# LSC Responses to TIS Redline Comments

## Villas at Claremont Ranch Traffic Impact Analysis

LSC #204130

RE: Villas at Claremont Ranch  
El Paso County, Colorado  
Traffic Impact Analysis  
LSC #204130

3
3 OF 13
PUDSP211

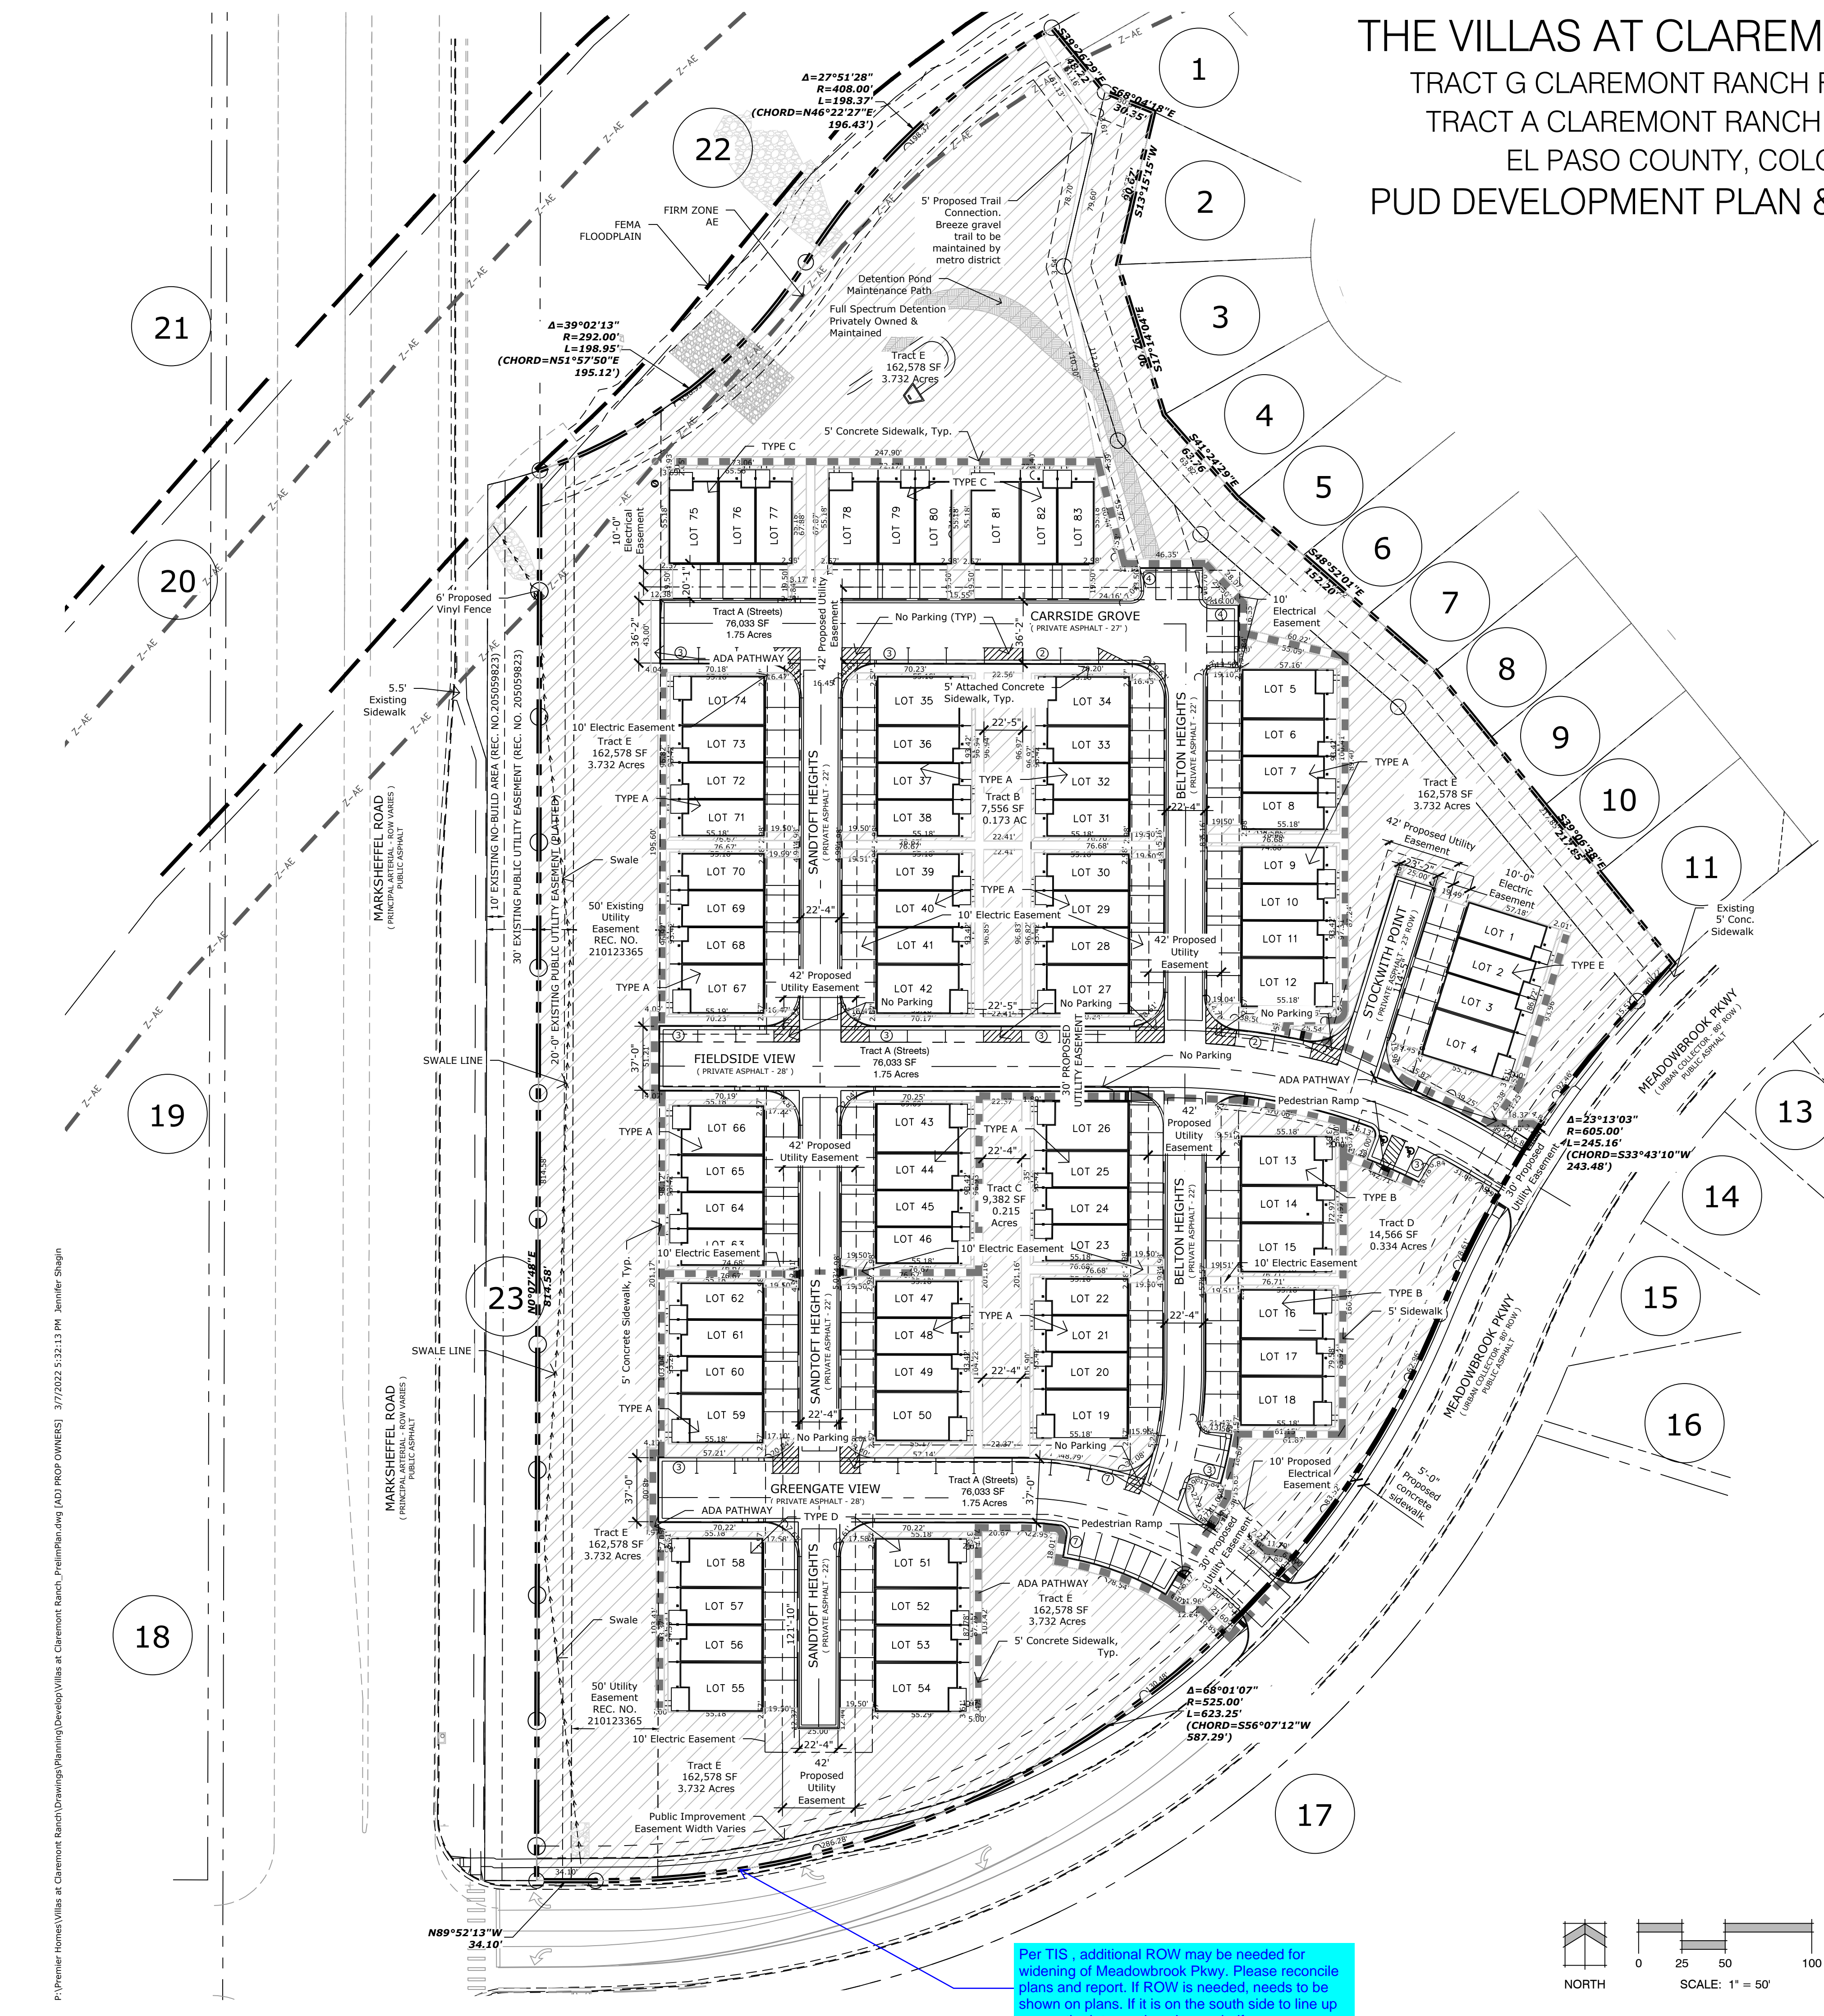
This needs to be provided on the PUD/SP plan

This needs to be provided on the PUD/SP plan

It is anticipated that additional right-of-way will be required for the widening of westbound Meadowbrook Parkway at Marksheffel Road.

LSC Note: The ROW line has been placed to accommodate the potential future laneage depicted on Exhibit 1 in this TIS report.
